Reference No:	2023/62/93719/E
Site Address:	992, Bradford Road, East Bierley, BD4 6PB
Description:	Erection of single storey rear extension
Recommending Officer:	Morgan Braithwaite

DECISION – CONDITIONAL FULL PERMISSION

OFFICER REPORT

PROPOSED REAR ELEVATION

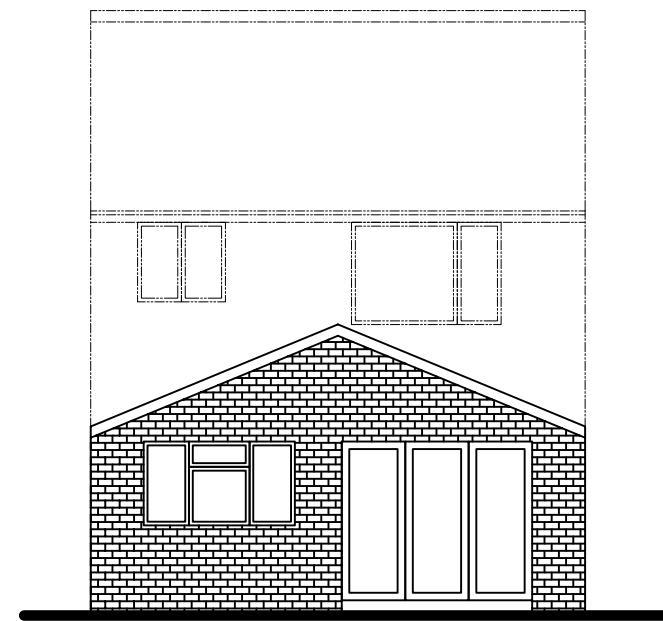
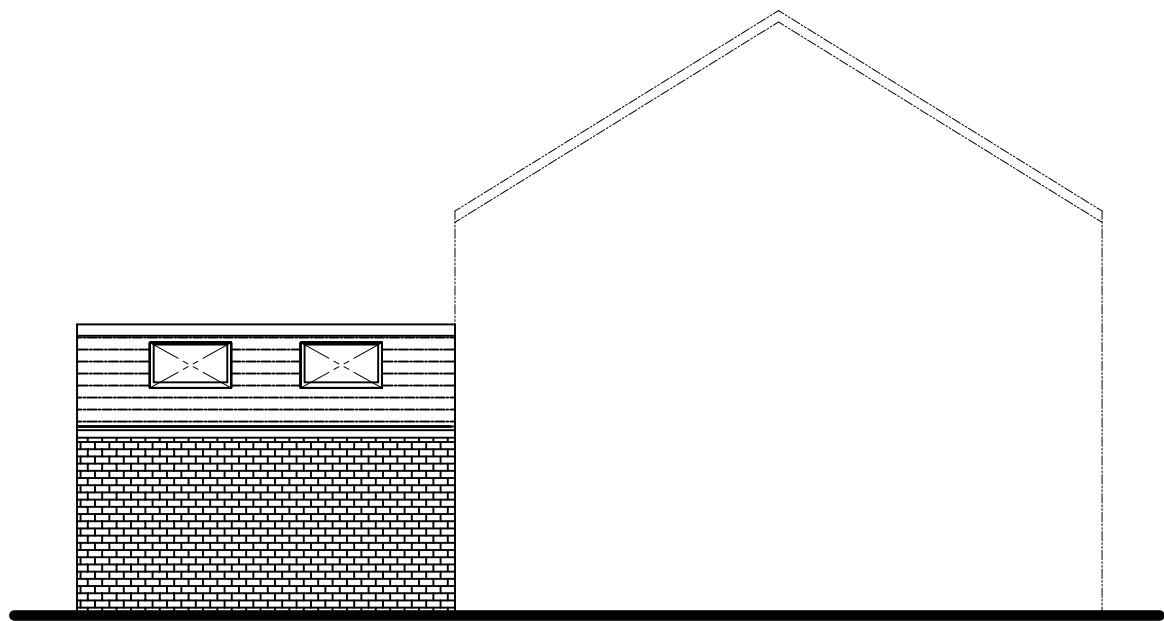
The proposed extension would project approximately 5m from the rear elevation of the existing dwellinghouse, with a length of approximately 6.5m. The proposal would feature a pitched roof with a ridge height of 3.7m and an eaves height of 2.4m.

The proposal would be constructed with stone, matching the existing dwelling.

The proposal would not be visible from the street scene, as the proposal is to form a rear extension to the original dwelling. The proposal would create a single storey extension, the materials of the proposal would be in keeping with the host dwelling.

PROPOSED GROUND FLOOR PLAN

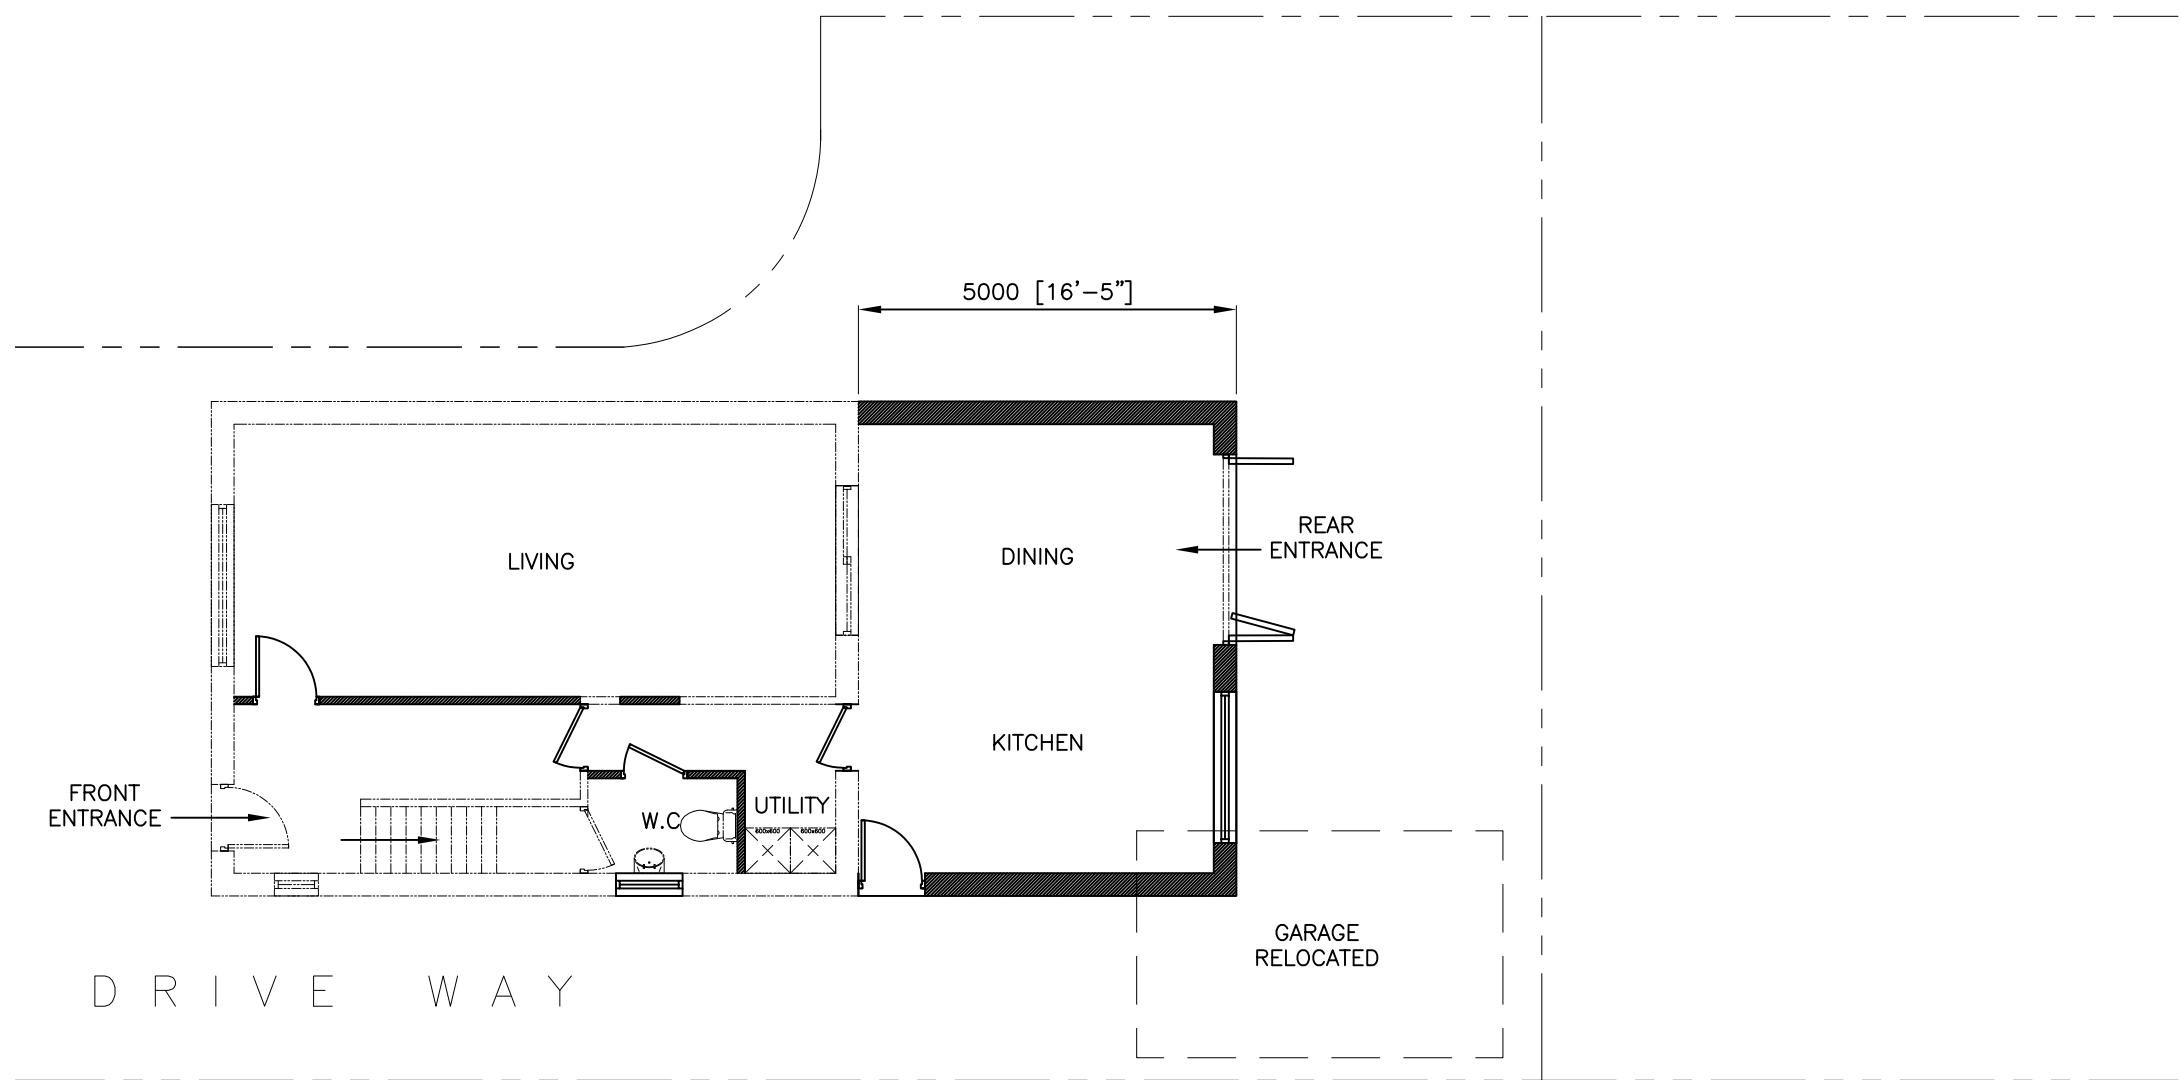
It is noted, however, that the proposal does not comply with Chapter 5 of the House Extensions and Alterations SPD, which states that the maximum projection from a detached dwelling is 4m. The proposal is for an extension which would project 5m from the rear elevation of the original dwelling. An application for a 4 metre extension has previously been approved and this has been extended to 5 metres which is considered large relative to the host. However, the host building would remain dominant within the plot, it is also set off both boundaries. The scale is beginning to appear obtrusive within the plot, however the garage is removed improving space around the dwelling as extended. It is to the rear of the site and screened by existing neighbouring development. As such, on balance, the projection proposed can be supported in this instance.

The size of the extension would cover some of the amenity space of the application property. It is considered that whilst the extension would increase built form on useable amenity space, the removal of the garage off sets the provision and sufficient amenity space would be retained. Therefore, the proposal would be acceptable in terms of the residential amenity of future occupiers of the dwelling.

The proposal would result in some intensification of the domestic use of the property. However, the proposal would not see the addition of further bedrooms but would see the demolition of the existing garage. This, however, would not remove a parking space as there is sufficient space for the required number of car parking spaces remaining.
